This submission is being made by H. Harold Secretary of the Castlefield Park Residents Association on behalf of the Castlefield Park Residents Association (address c/o 29 Castlefield Park, Clonsilla D15.).

The Castlefield Park Residents Association would like to make the following submission on the Railway Order that Irish Rail have submitted for the DARTWest project (Reference 314232).

MAY MDC STR LC03 DR C 0203 D

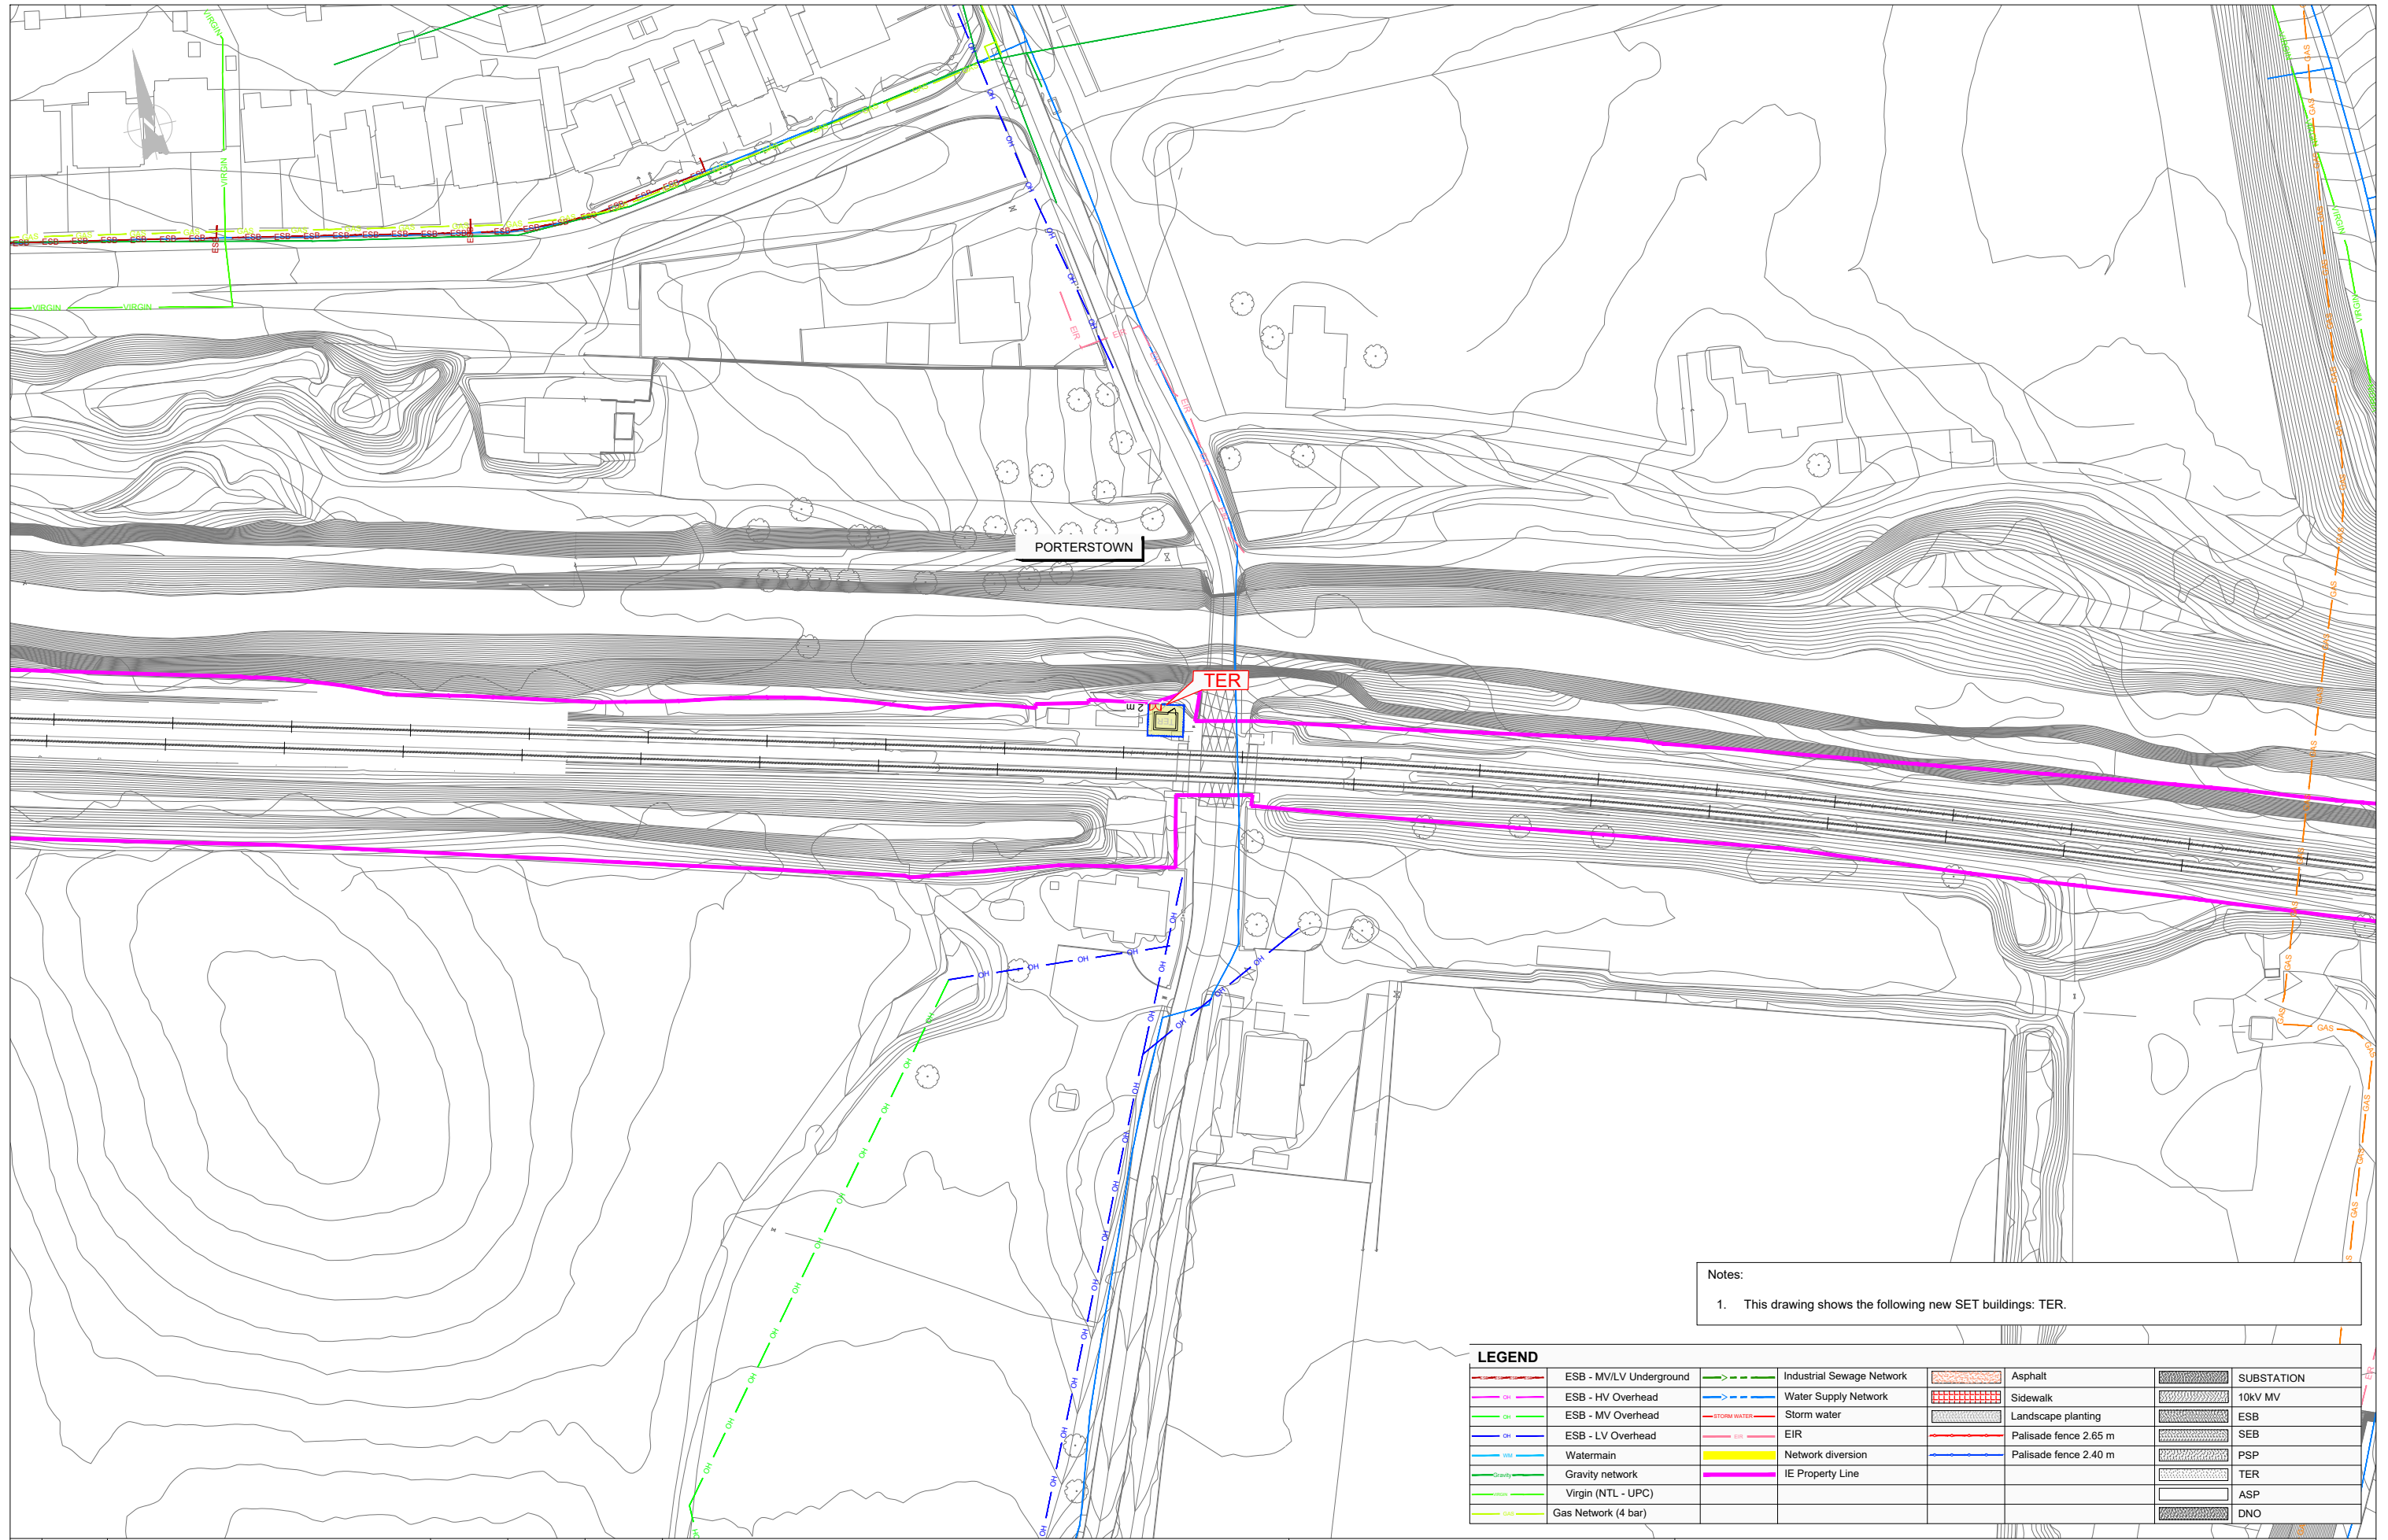
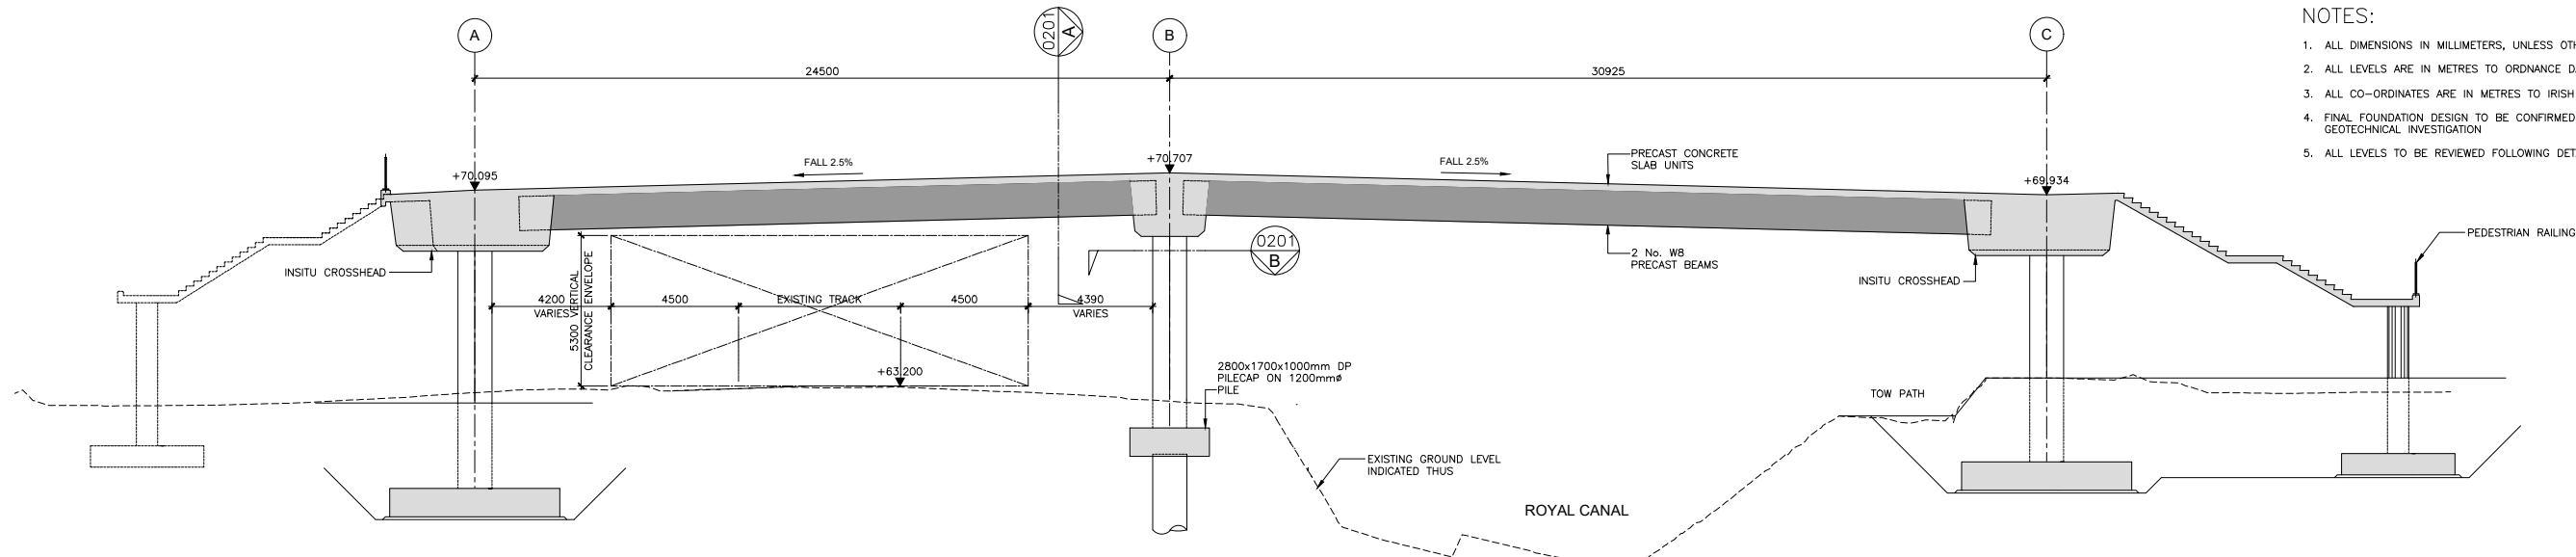
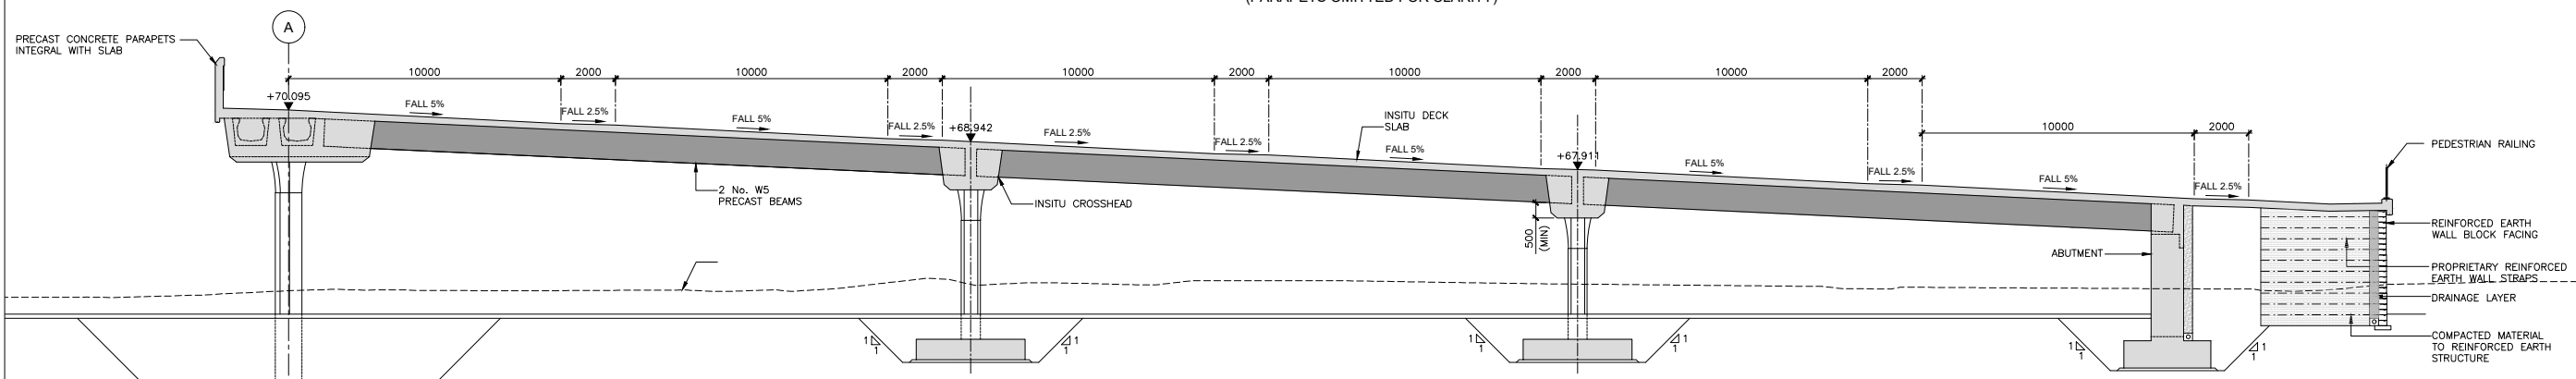
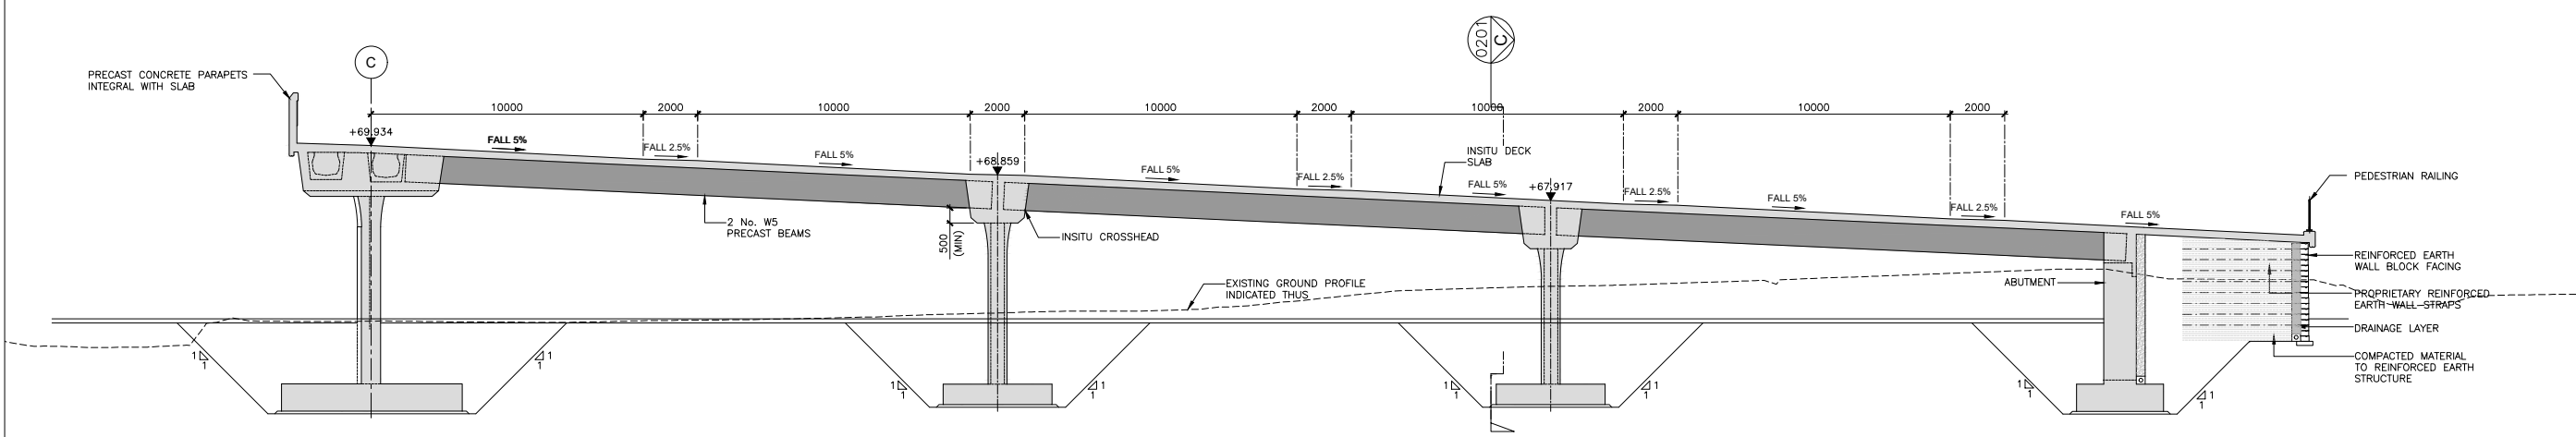
- The proposed access bridges at Clonsilla and Porterstown are unsightly and will dominate the view in these areas. This is of particular concern as both bridges are being built near historic elements that form part of the unique heritage and character of Clonsilla Village. The Porterstown bridge is beside the Old Schoolhouse which is a protected structure and the Clonsilla bridge is immediately adjacent to four protected structures; Callaghan Bridge, Clonsilla Signal Box, Clonsilla Overbridge and St Marys Church. There are more suitable locations for any bridge further to the west of these protected structures. The area around the Old Schoolhouse and the area around St Mary's Church are of key significance to the unique character and built heritage of Clonsilla.

- The proposed access bridges at Clonsilla and Porterstown are located at the site of the proposed Greenway and in a proposed Natural Heritage Area. The large size and unsightly nature of the bridges will impact negatively on the Greenway and the ecology and biodiversity of the proposed Natural Heritage Area.
